Arun District Council
Arun Civic Centre
Maltravers Road
Littlehampton
West Sussex BN17 5LF
Planning & Building Control General Enquiries
Tel: (01903) 737756 Fax: (01903) 730442
Dx: 57406 Littlehampton
Minicom: 01903 732765
e-mail: planning@arun.gov.uk
website: www.arun.gov.uk/planning

Application No: K/16/21/HH
Site Address: Sea Lodge 7 Coastal Road Kingston BN16 1SJ
Description of works: Internal alterations to existing dwelling. Demolition and replacement of existing rear extension with new single storey extension and first floor terrace above with external staircase. Replacement of main roof and 4no. new dormers with windows. Replacement roof tiles to single-storey projections on North elevation. Proposed rear single storey minor extension to garage to form entrance lobby. Alterations to external facade of house and replacement windows and doors throughout. Associated landscaping to suit.

Thank you for your internet representation made on 16th June 2021 which has been recorded as an objection with the comments as follows:

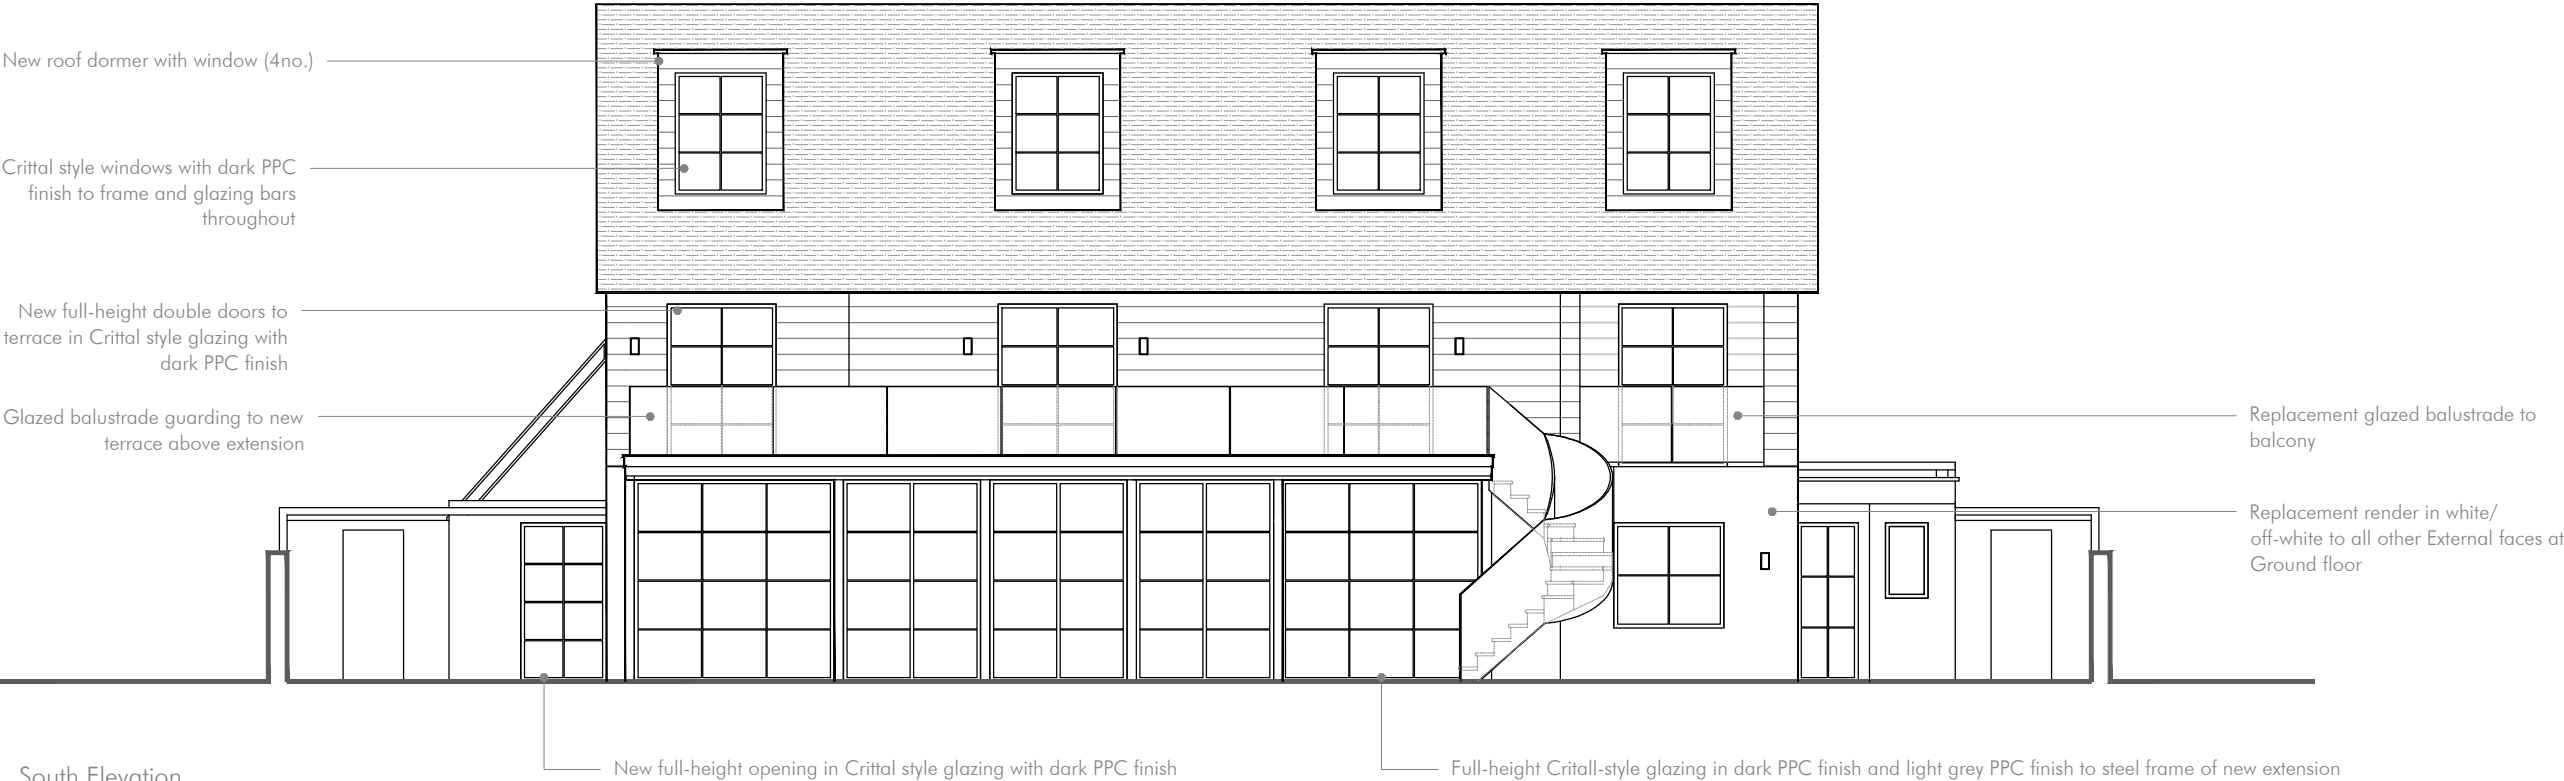
the additional one metre plus in height of the roofline and new bedrooms:

It will cause significant shadowing to my main first floor and ground floor terraces (which have seating and dining provision) as well as pose a clear invasion of privacy to both areas.

Both are used extensively and are currently not overlooked .
